## COMMENT RESPONSE NARRATIVE

DATE: June 20, 2023  
PROJECT ARCHITECT: ELEVEN18 ARCHITECTURE, PL  
CONTACT NAME AND NUMBER: Matt Conte, AIA LEED AP | 407-745-5300

PROJECT NAME: **The Springs of Ballentine**  
PERMIT NUMBER:

PLEASE NOTE THE FOLLOWING REVISIONS TO THE PROPOSED SET OF DRAWINGS HAVE BEEN COMPLETED IN RESPONSE TO THE NORTH CAROLINA DEPARTMENT OF HEALTH AND HUMAN SERVICES FOR THE ARCHITECTURAL REVIEW DATED 4/12/2023 AND MEP REVIEW DATED 6/7/2023 AS WELL AS CITY COMMENTS DATE 6/13/2023.

**A401**  
 WALL SECTIONS

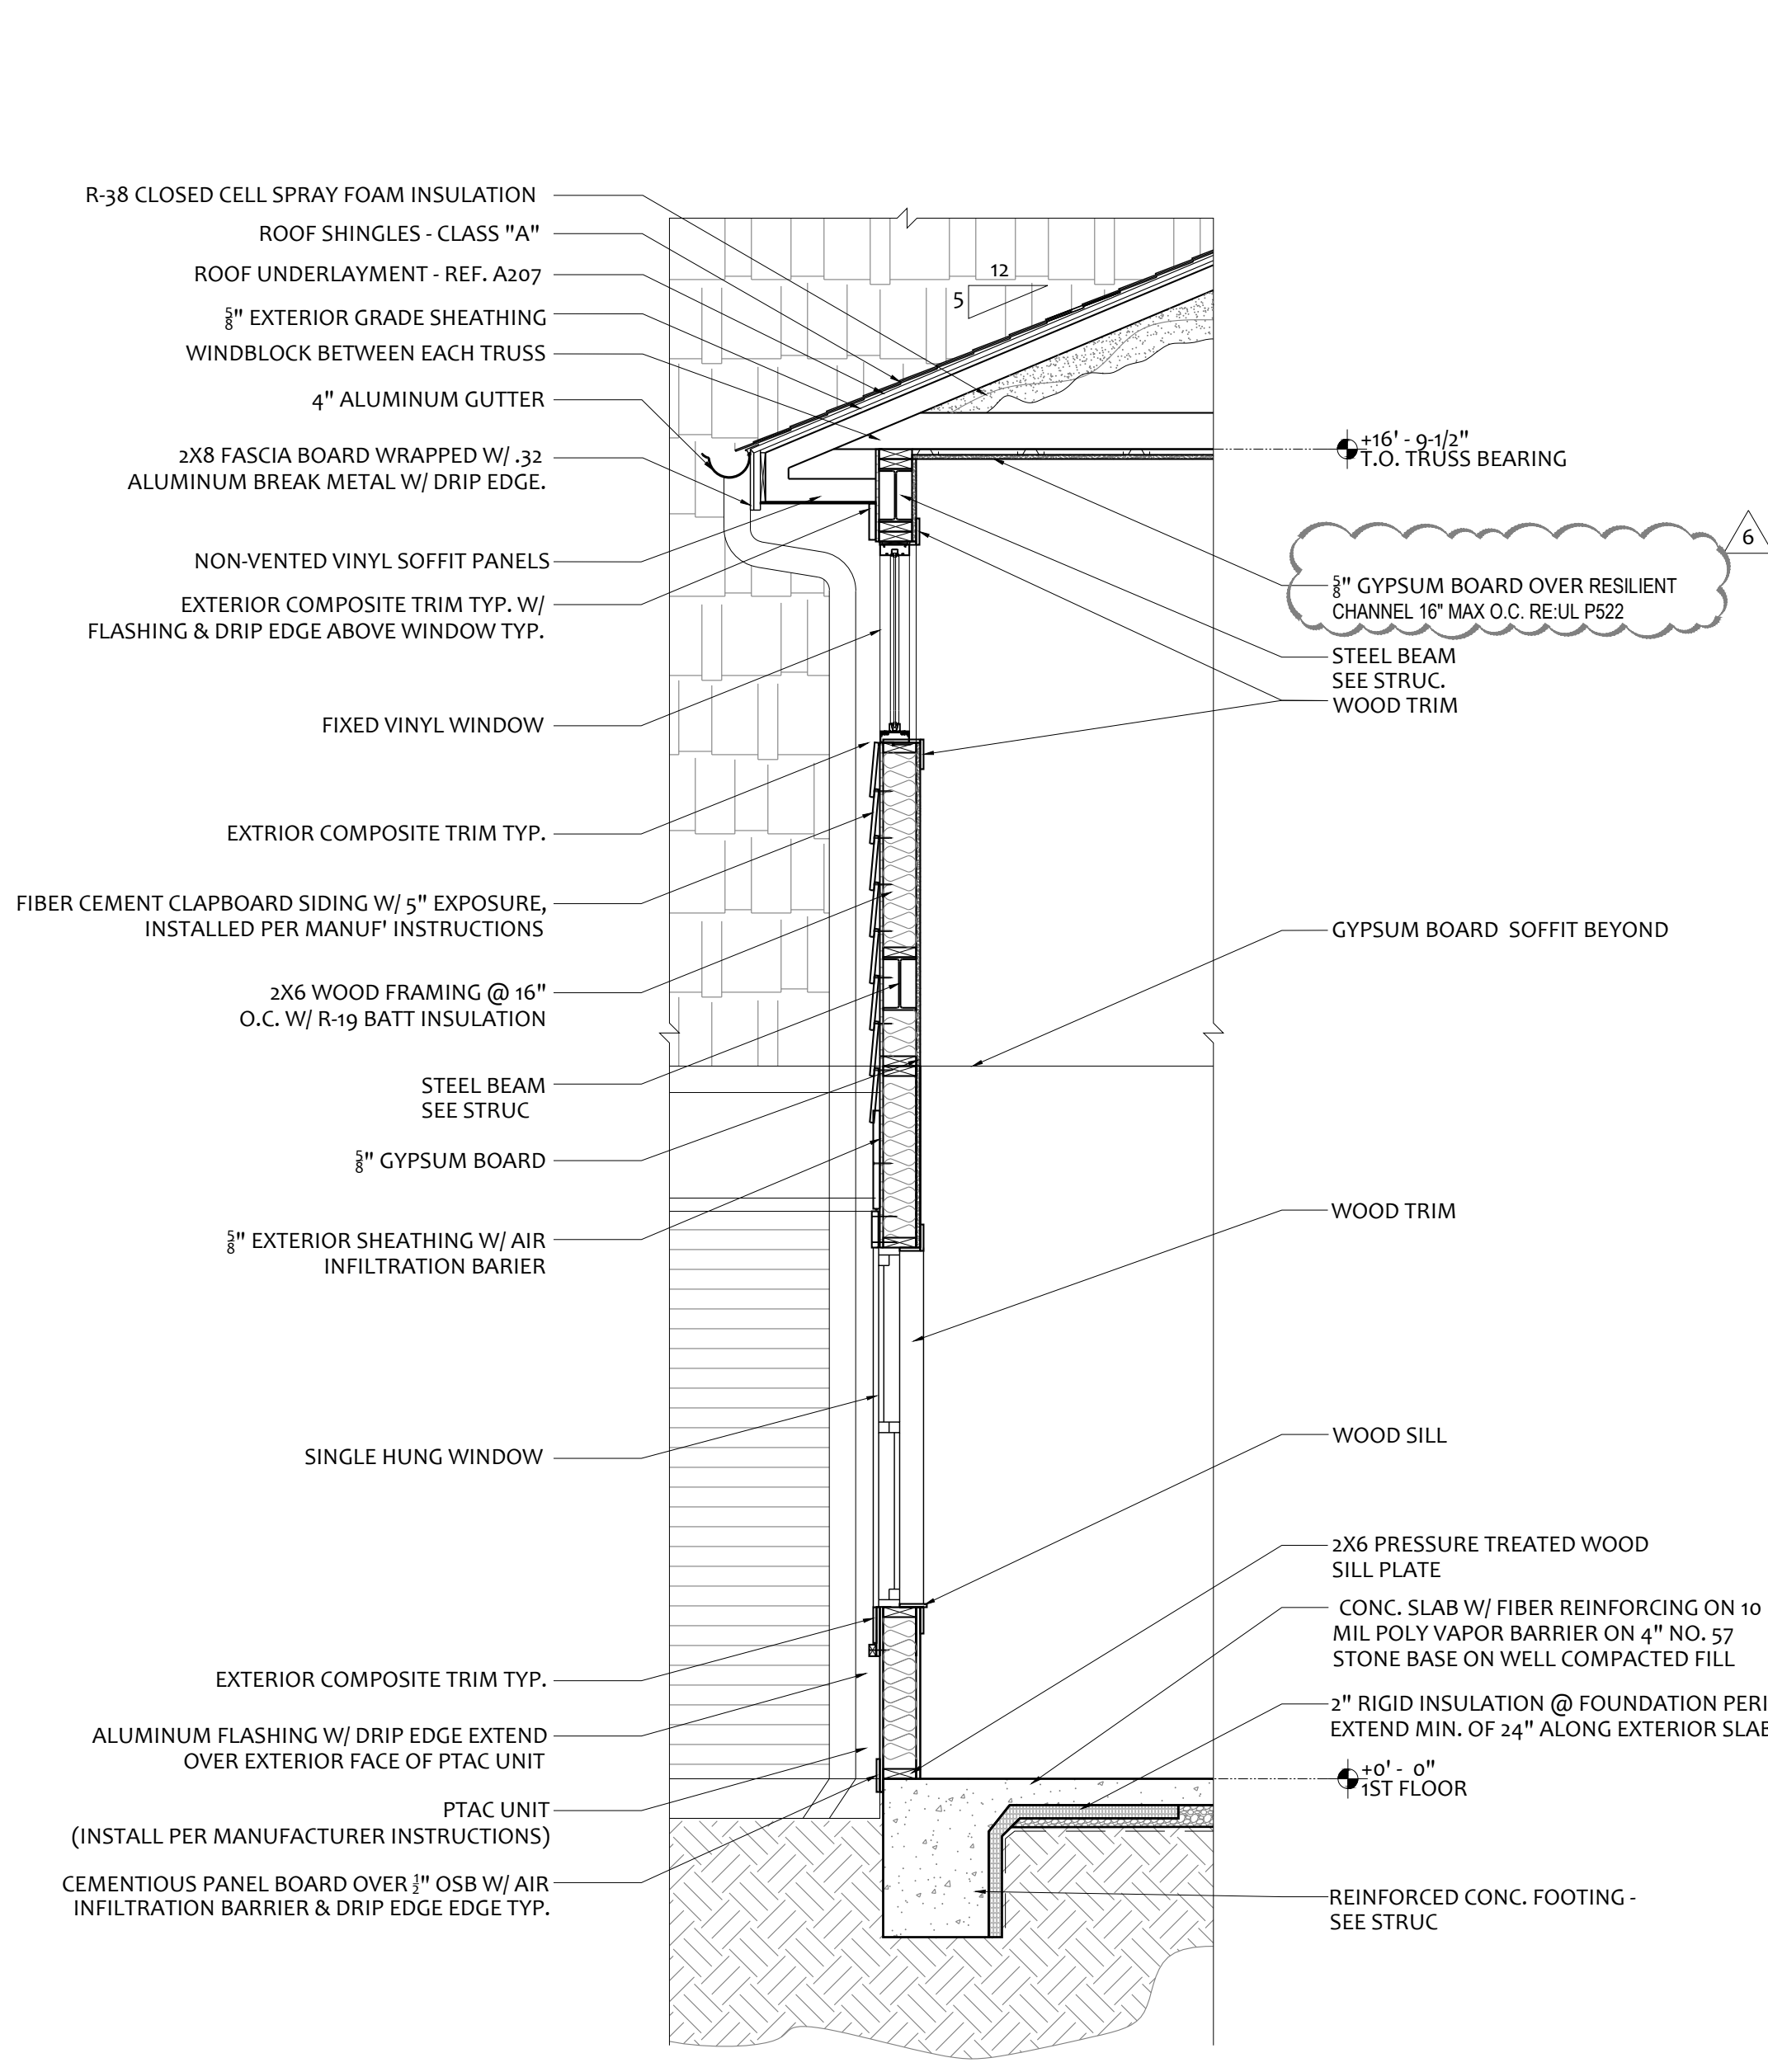
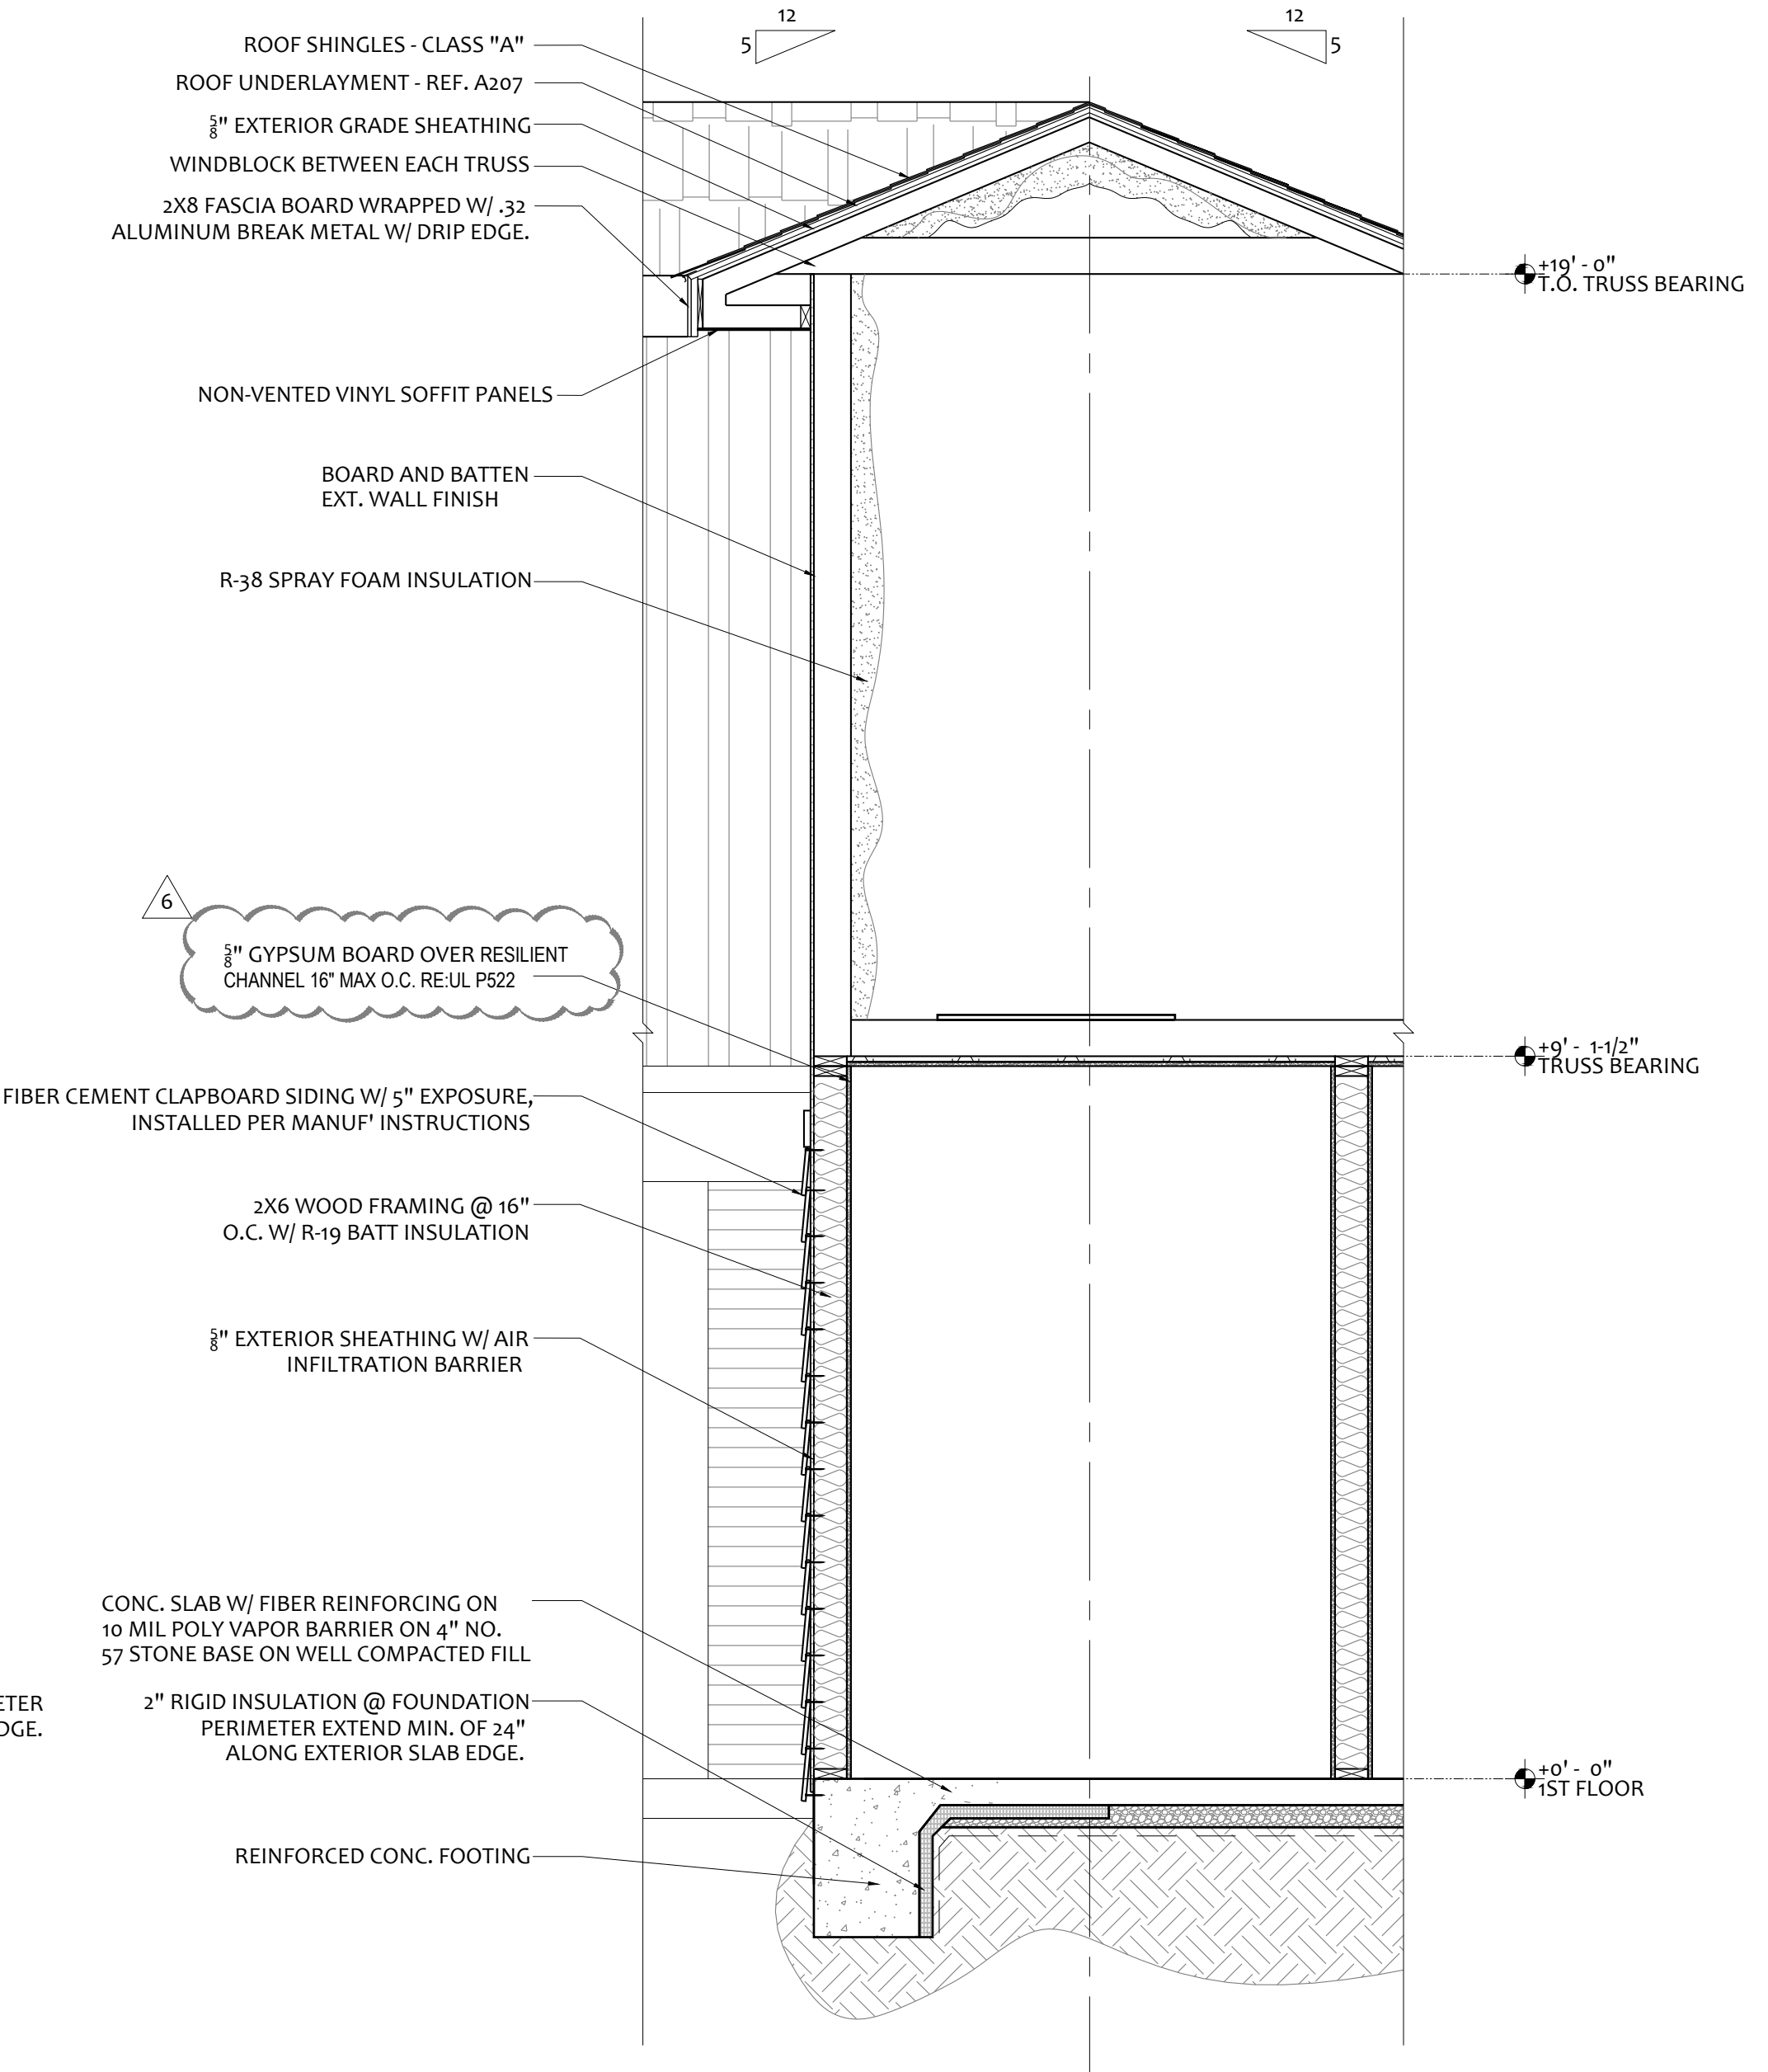
**3. The 1-hour roof ceiling assembly P522 on Sheet A006 was tested with specific products. Please submit confirmation that that specific product was used if this assembly is used with the 16" on center resilient channels.**

**RESPONSE:** P522 on sheet A006 has been moved to sheet A013 per revision 4. All sections and details have been updated from "hat track" to "resilient channel." Refer to revised sheets A302 – A305 and A401-A405. If another alternate product is used as part of P522 the contractor/architect will submit that information to the AHJ.
